CITY OF ALBUQUERQUE

April 25, 2011

**Re: HME Specialists, 5101 McLeod Rd NE, Traffic Circulation Layout
Architect's Stamp undated (E16-D020)**

TCL

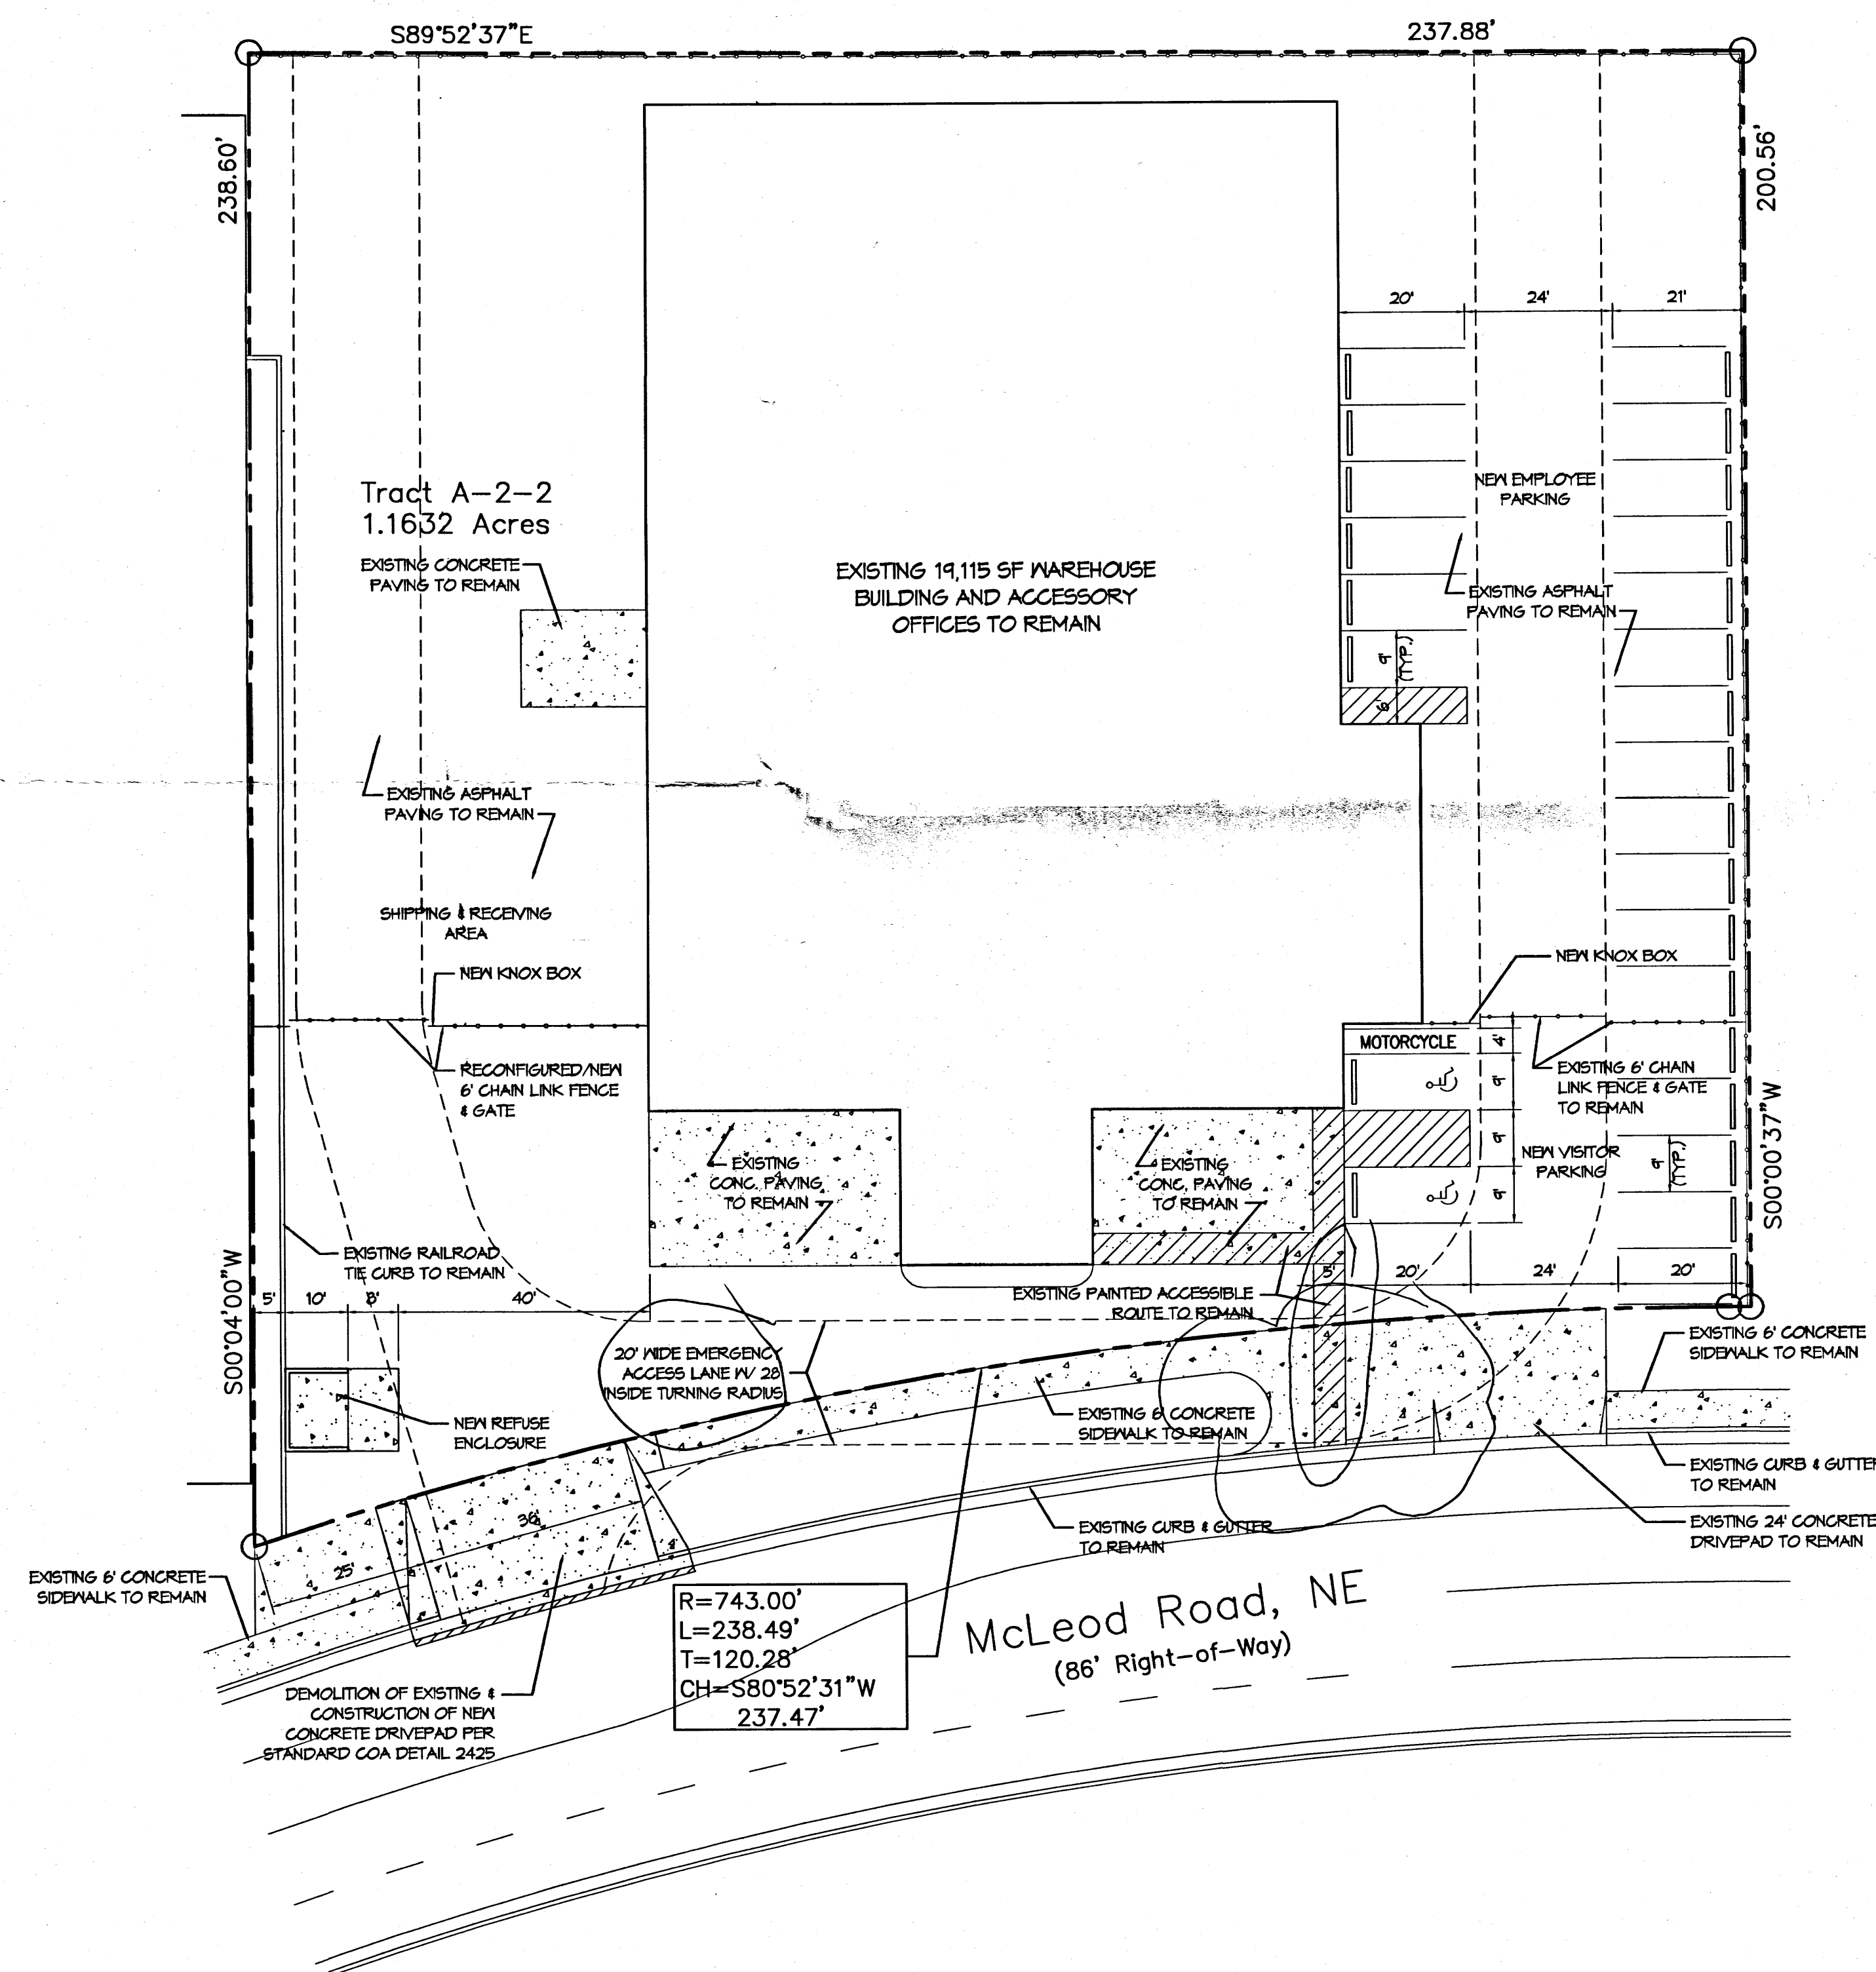
1. A five-foot keyway is required for deadend parking aisles.
2. Remove the parking stall proposed directly behind the gate.
3. A six-foot wide, ADA accessible, pedestrian pathway is required from the public sidewalk to the building. This pathway cannot be located within the vehicular way.

4. Provide additional information regarding the eastern curb cut. A 24-foot wide drivepad is shown within the curb cut, but additional width is also shown. Why would this curb cut be expanded? Please clarify.

5. Clarify existing versus proposed conditions.
6. Please list the width and length for all parking spaces.
7. The emergency access lane cannot cross over the sidewalk.

8. What is the purpose of the western curb cut?
9. Please show the location of the nearest driveway on the adjacent lot.
10. The traffic circulation layout must be stamped, signed, and dated by an engineer or architect licensed in the state of New Mexico.
